Tuck O'Brien  
City Planning Director, Planning Division

March 18, 2016

Project Name: **Six Unit Commercial Building; Amendment for Safelite AutoGlass**  
Project ID: 2014-016 CBL: 296-A006001  
Address: 421 Warren Avenue, Portland  
Joint Applicants: PH Warren Avenue, LLC  
Planner: Jean Fraser

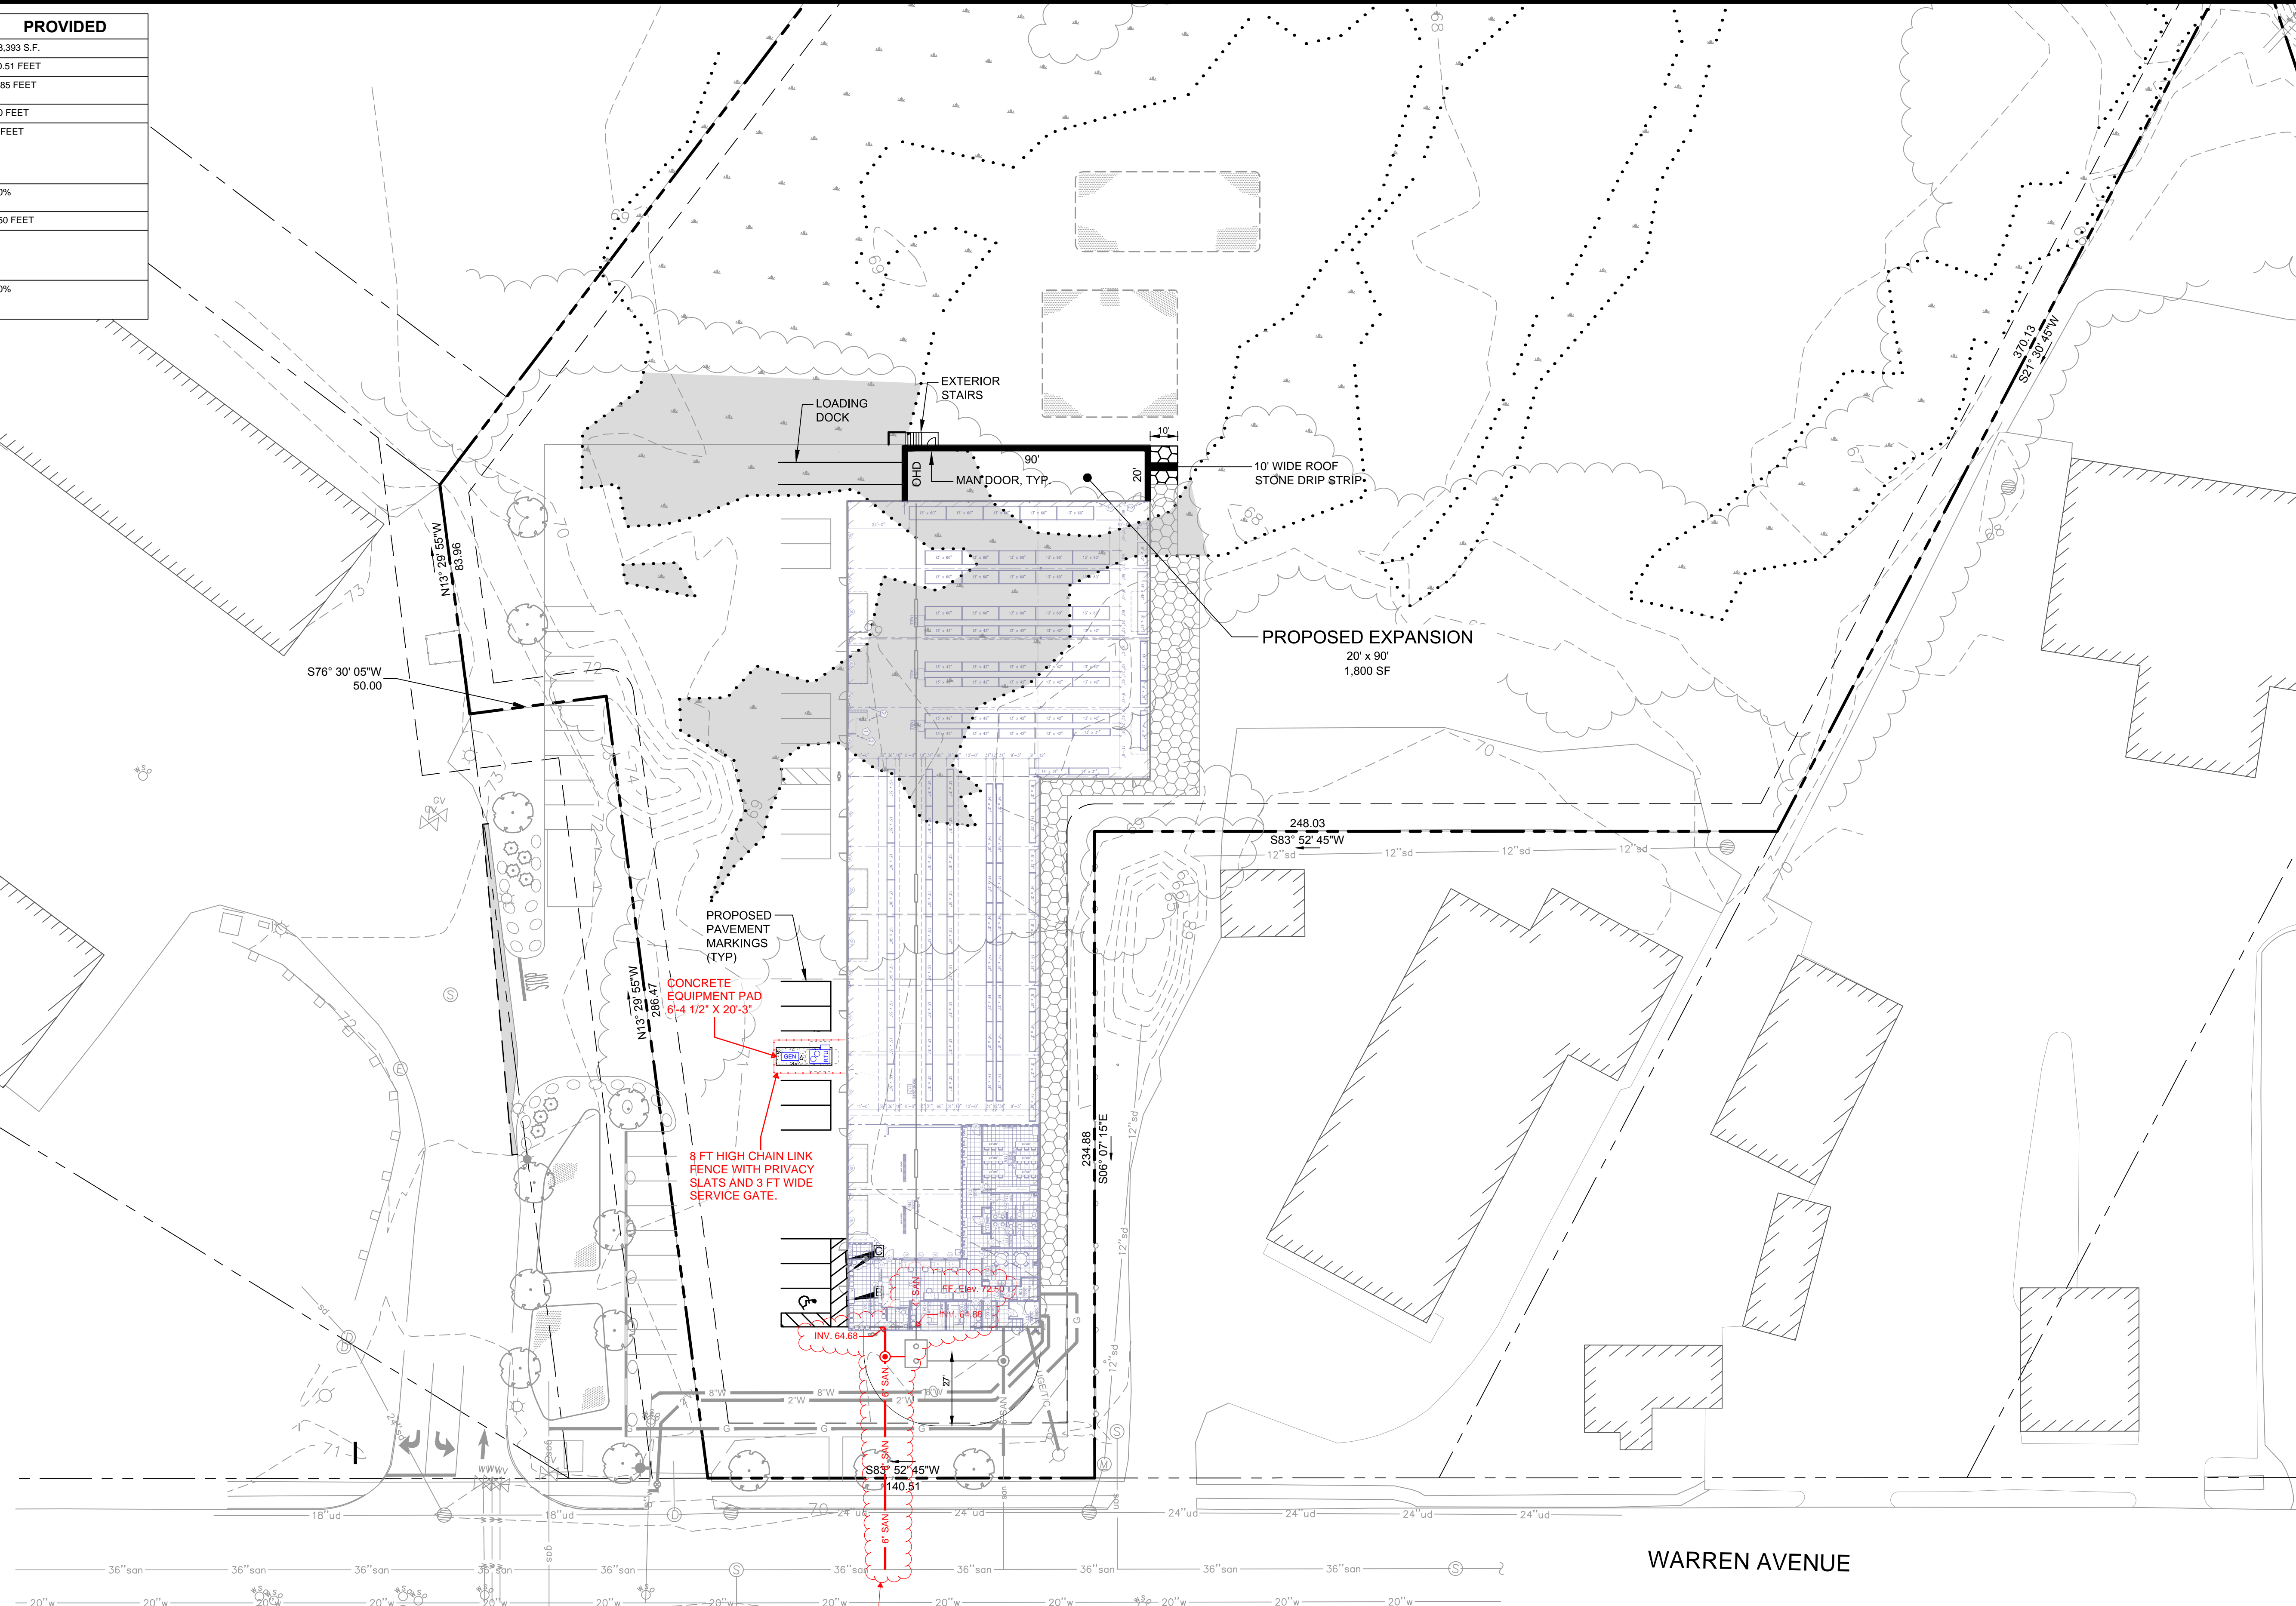
1. That the new generator located within the site shall meet applicable state and federal emissions, shall be screened from view from Warren Avenue, and shall not be activated for more than one hour per week for routine maintenance and testing. Noise levels shall not exceed City B4 zone standards except in designated emergencies or for emergency generator testing. Emergency generator testing is permitted only between the hours of 9:00 a.m. and 5:00 p.m., Monday through Friday; and
2. That separate reviews and permits are required from the Inspections Division for all new or modified signs; and
3. That condition #viii in the May 27, 2014 Planning Board approval letter is removed; the site was amended to 5.94 acres, as confirmed and approved by the Planning Authority on 8.25.201.

The approval is based on the submitted site plans from Stantec: Site Layout C-3.0 (Rev 9); Grading and Drainage C-4.0 (Rev 6) and Safelite Floor Plan A-1. The commercial building may be occupied as one building (as Safelite propose) or for up to 6 units as indicated in the original proposal, subject to any site or external building modifications when an amended site plan must be submitted for staff review and approval.
